WEST SUSSEX COUNTY COUNCIL CONSULTATION

TO:	Arun District Council FAO: Mrs A Gardner
FROM:	Highways, WSCC
DATE:	10/04/2018
LOCATION:	14-18, Surrey Street, Littlehampton, West Sussex, BN17 5BG
SUBJECT:	LU/67/18/PL Change of use of part of public highway for external seating area at front comprising of 4 No. tables & 8 No. chairs. This application may affect the setting of a listed building.
DATE OF SITE VISIT:	n/a
RECOMMENDATION:	☒ Advice ☐ Objection ☒ Modification ☐ No Objection ☐ More Information ☐ Refusal
S106 CONTRIBUTION TOTAL:	n/a

CLIENT	JD WETHERSPOON PLC		
PROJECT	PUB NO: 534 THE GEORGE INN LITTLEHAMPTON		
DRAWING	PROPOSED PAVEMENT CAFE		
SCALE	A3/1:50	DATE	MAR 2018
PROJECT No	7508	DRAWING No	03
		DRAWN	ALS
		REVISION

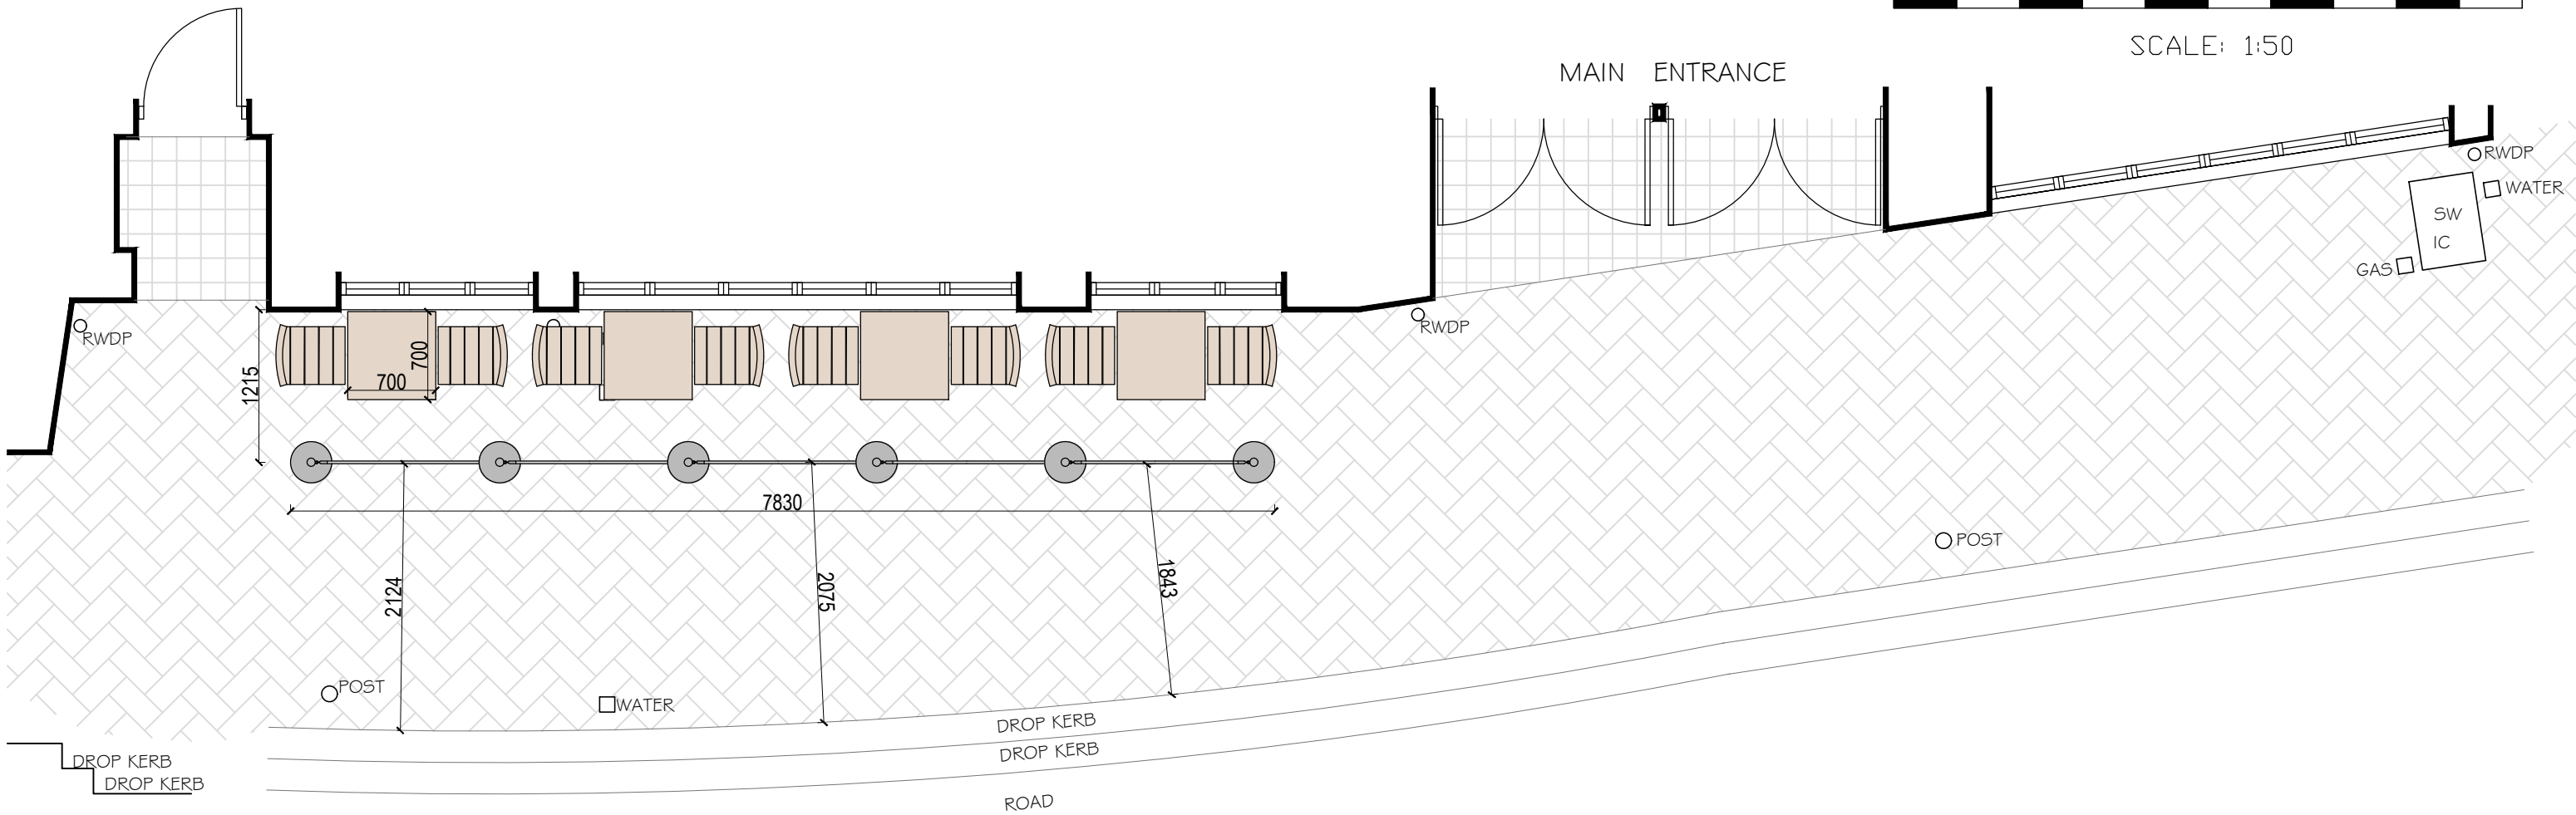
After inspection of the plans provided the proposed would result in a narrowing of the footway to circa 1.8 metres with additional obstruction caused by existing street furniture within the immediate vicinity, namely a street lighting column and parking restrictions signage pole.

Manual for Streets advised that a minimum footway width of 2.0 metres is considered acceptable. This is expanded upon in section 3.1 of the DFT publication 'Inclusive Mobility' which states the following regarding footway widths:

"A clear width of 2000mm allows two wheelchairs to pass one another comfortably. This should be regarded as the minimum under normal circumstances."

Consideration also needs to be given that this is a town centre location with high footfall.

The footway width in this location currently accords to recognised guidance. The Local Highways Authority would therefore not wish to seek any reduction below recognised guidance and standards.

I note the frontage of the public house does provide the opportunity to provide a reduced level of tables and chairs while retaining minimum acceptable footway widths across the frontage as advised above.

I would ask the applicant investigate modifying the proposal in line with the comments above. In its current form the Local Highways Authority would not be minded to support this application and any subsequent licence application to place tables and chairs would likely fail.
